OAKLANDS FARM SOLAR PARK

Applicant: Oaklands Farm Solar Ltd

The Applicant's Comments on Written Representations and other
Deadline 4 Submissions

Document Ref: EN010122/D5/13.3

Figure 4.9: Coton Road Crossroads Design

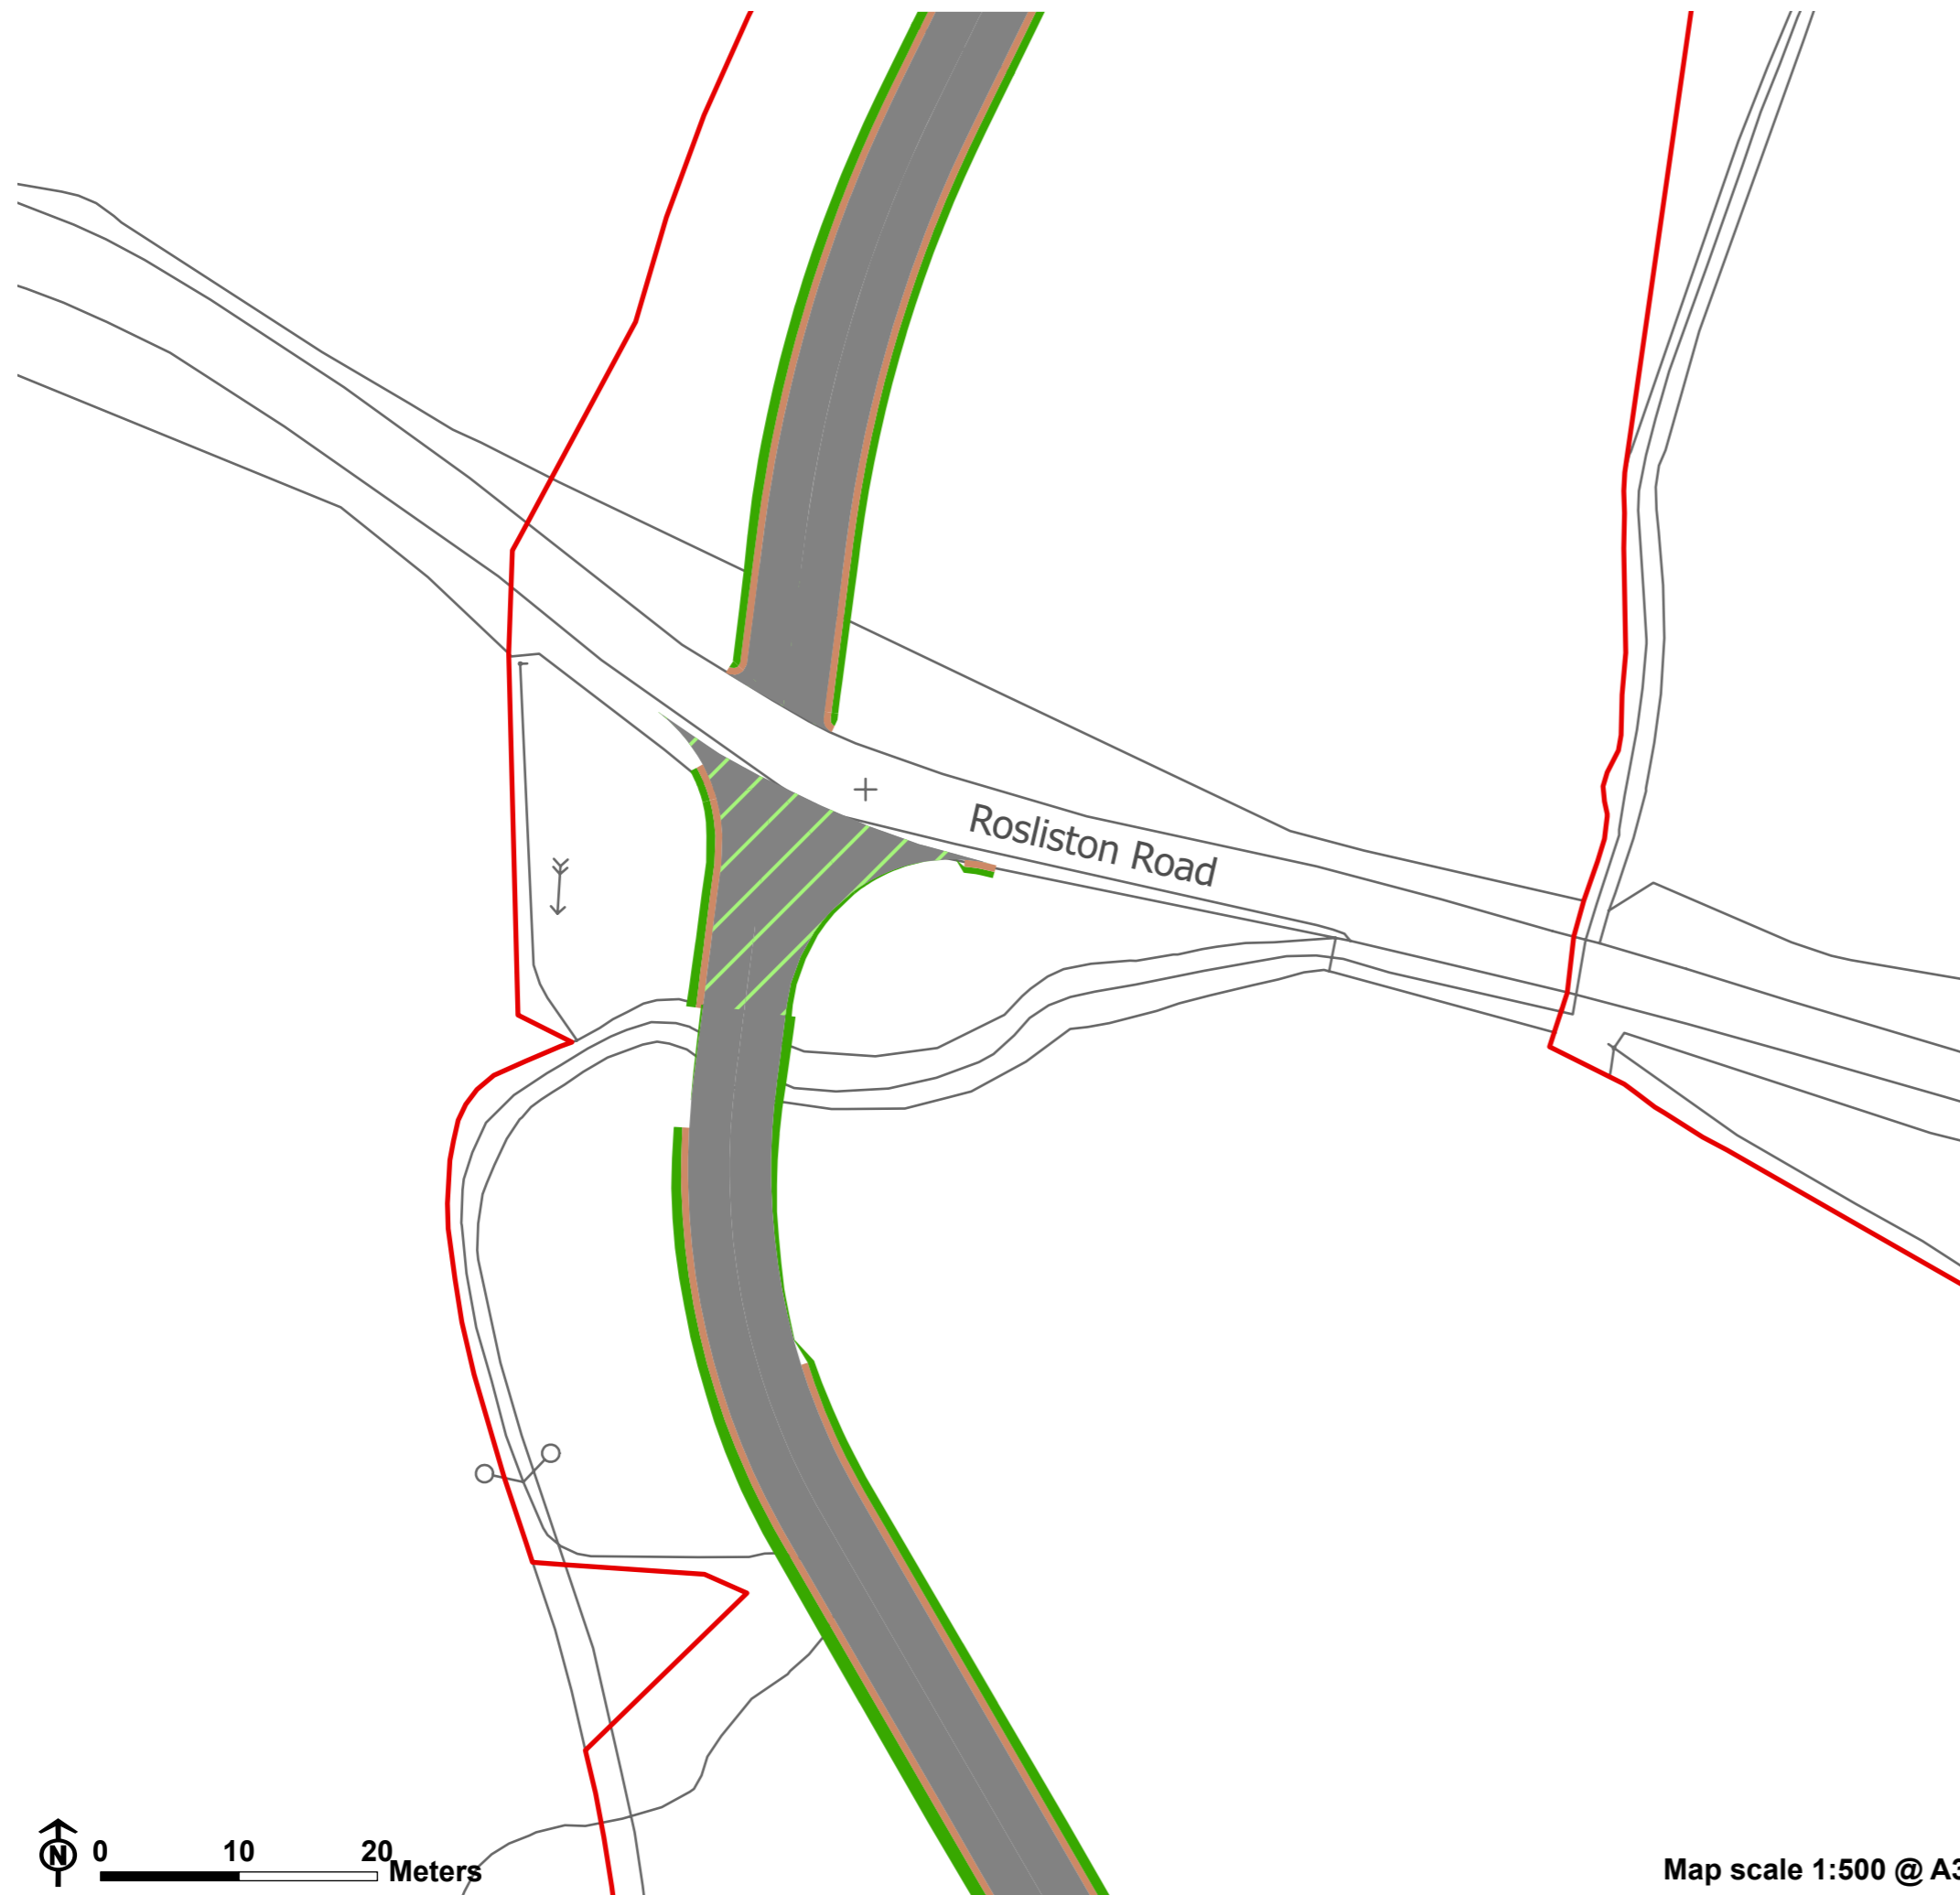
In respect of the proposed construction access at Coton Road, Figure 4.9 [APP-099] shows an indicative design for that access and demonstrates that the proposed access track will sit to the west of the Twin Oak and that it will be possible to use features like no dig construction to prevent impacts on that tree. The Works Plans identify areas within which features such as construction compounds will be provided, with specific details of their location and extent of those features to be defined at the detailed design stage.
